Our ref: DOC20/853943

**Response to Submission comments for Harbourside Shopping Centre Redevelopment (SSD 7874)**

Thank you for your referral dated 16 October 2020 inviting further comments from the Heritage Council of NSW on the above State Significant Development (SSD) Response to Submissions (RTS) for amended concept proposal.

/ Axonometric view of the northern podium

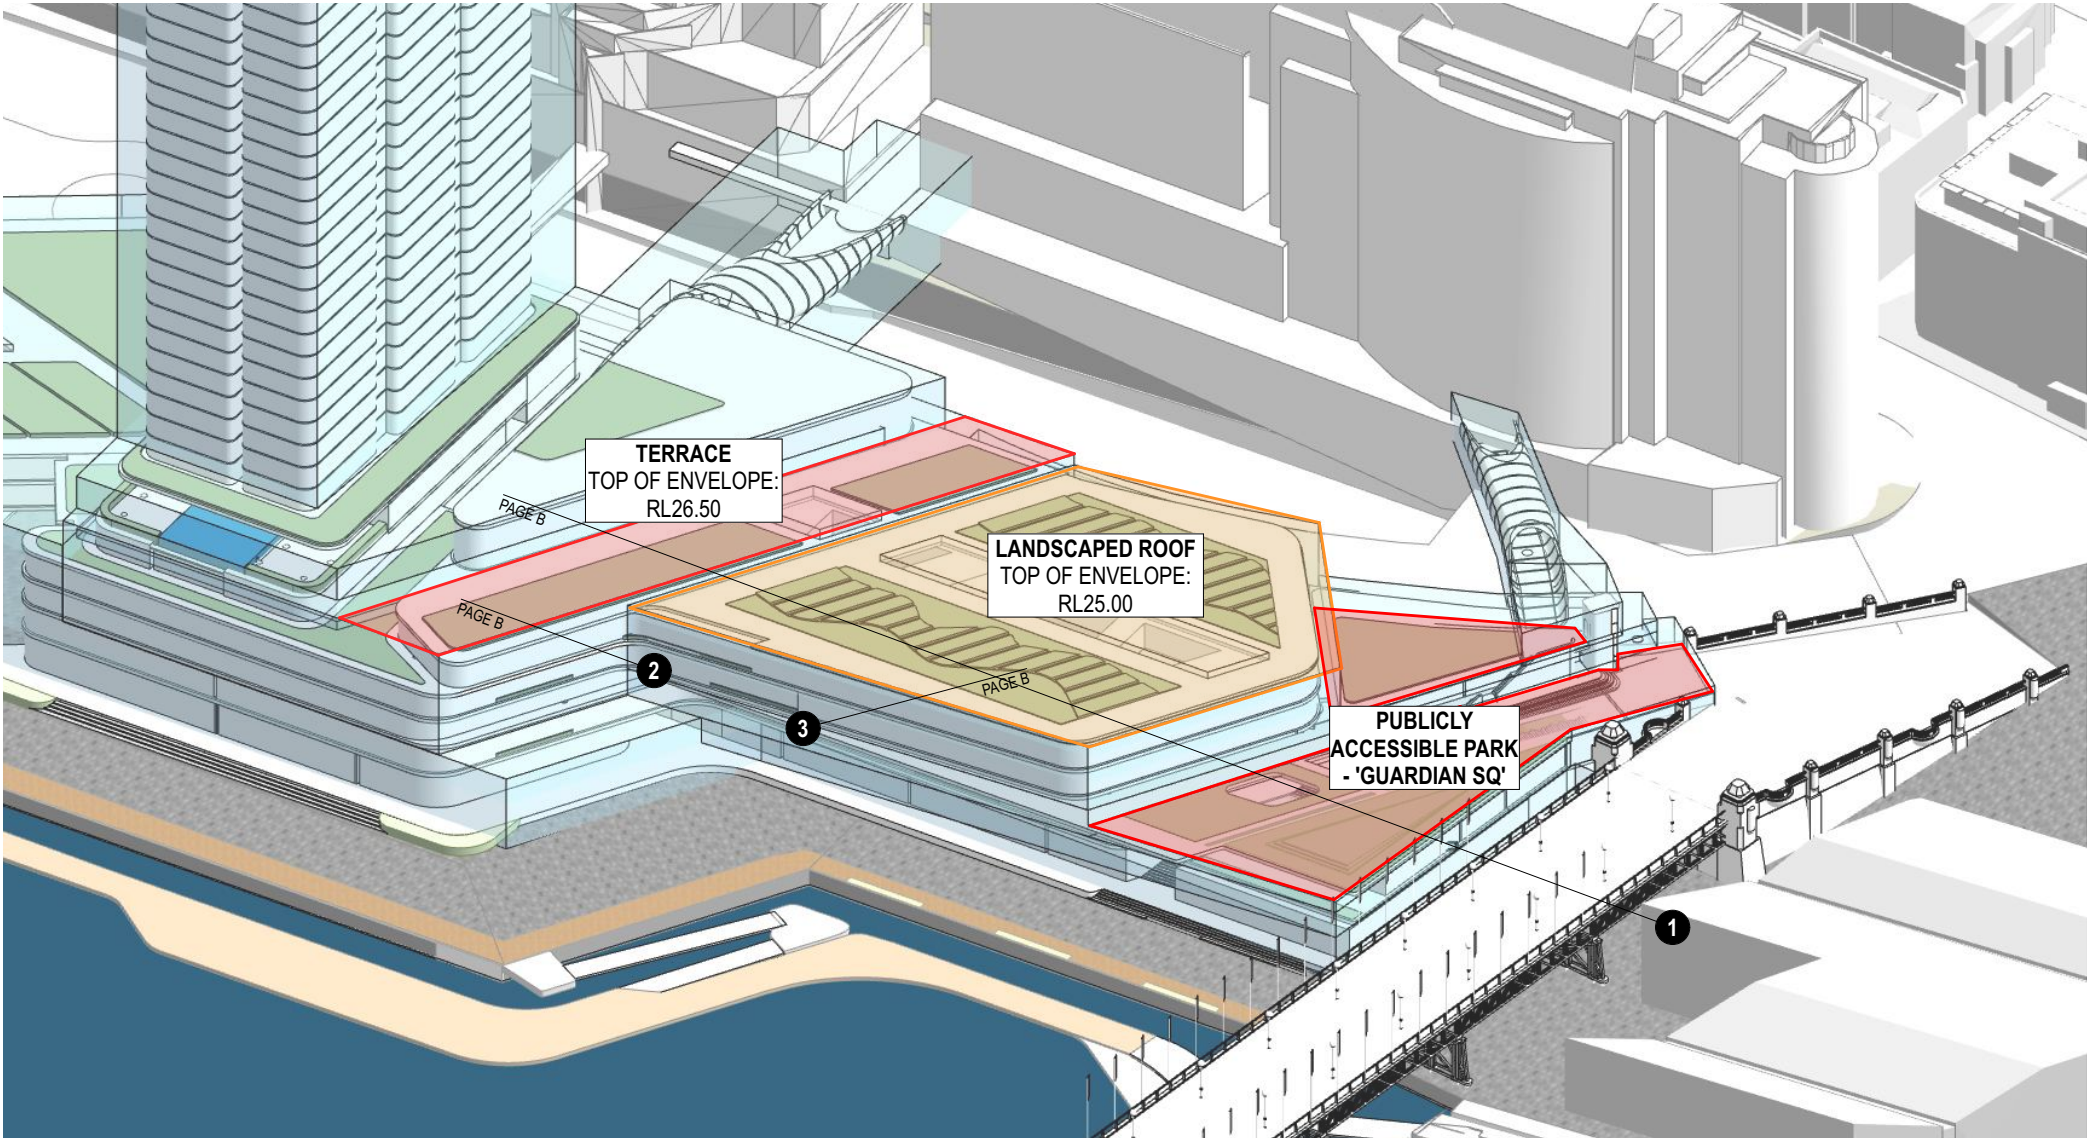
The further reduction in height of the northern podium and introduction of the new public open space level is supported as it provides a further set back and separation from the Pyrmont Bridge. The increased physical set back from Pyrmont Bridge is an improvement when compared to the first two submissions considered. This is based on review of Concept Proposal Indicative plans and 3D renders when viewed looking west across Darling Harbour, and photomontages developed for 50 Murray Street, Pyrmont. However, the view line from 50 Murray Street across Darling Harbour (which provides a visual setting for the Pyrmont Bridge) is impacted by the current height of the northern podium block. HNSW notes that the documents identify the current building envelope may be refined during detailed design and recommends a design which aims to retain the visual link of Pyrmont Bridge and Darling Harbour would be preferred as it provides context to the SHR item, and should be addressed by the SSDA stage 2 detailed design. This would be consistent with previous conditions recommended for detailed design to be sympathetic to the SHR listed values of Pyrmont Bridge.
